BURPHAM PARISH MEETING

12th August 2011

Ref: B/25/11 Lample House, Wepham

new shed drawn in purple
inside the outline of
dilapidated structure
which has been
demolished.

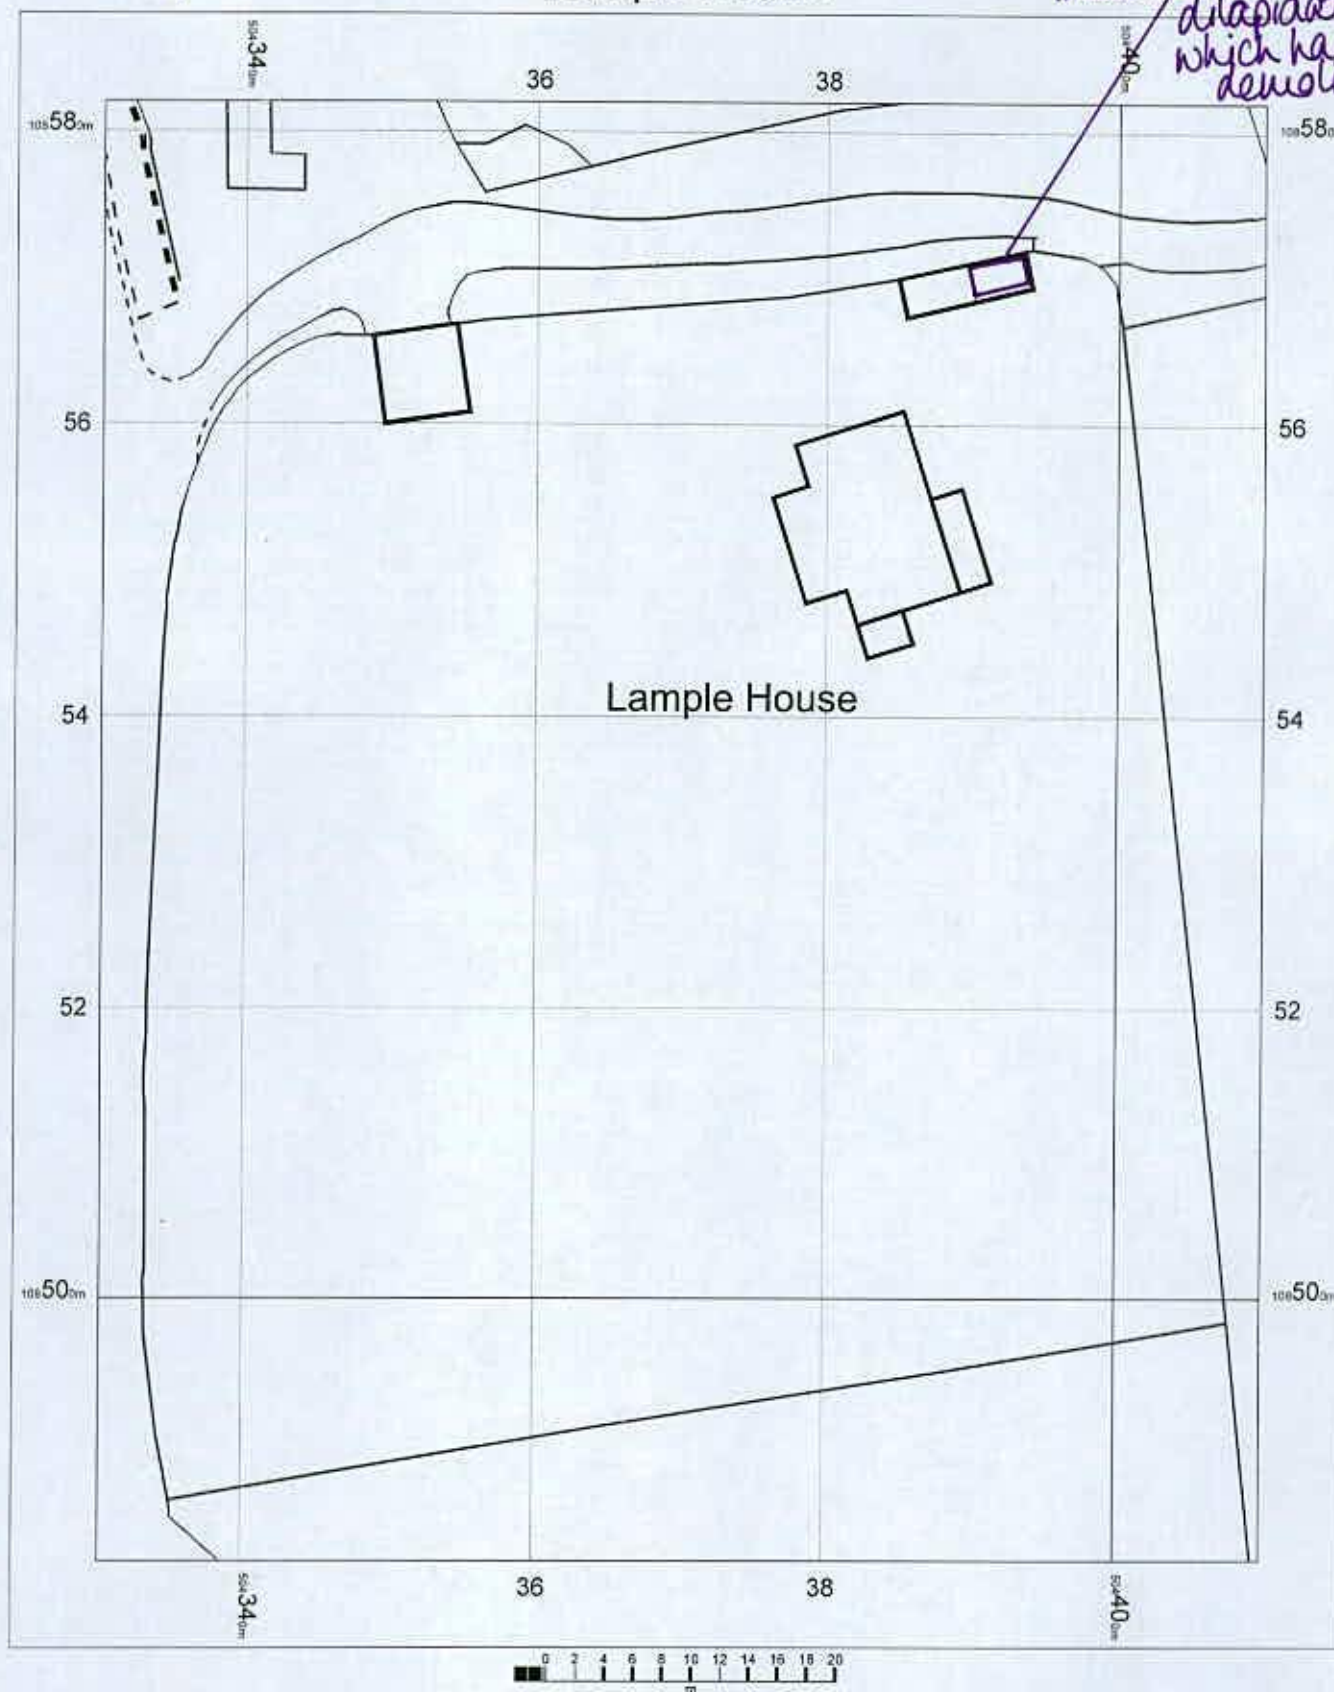
It is a large shed and was built without planning permission. The hedge between the shed and the public footpath has been removed, and we believe that the shed is built closer to the footpath than the demolished sheds. However it does not affect other properties.
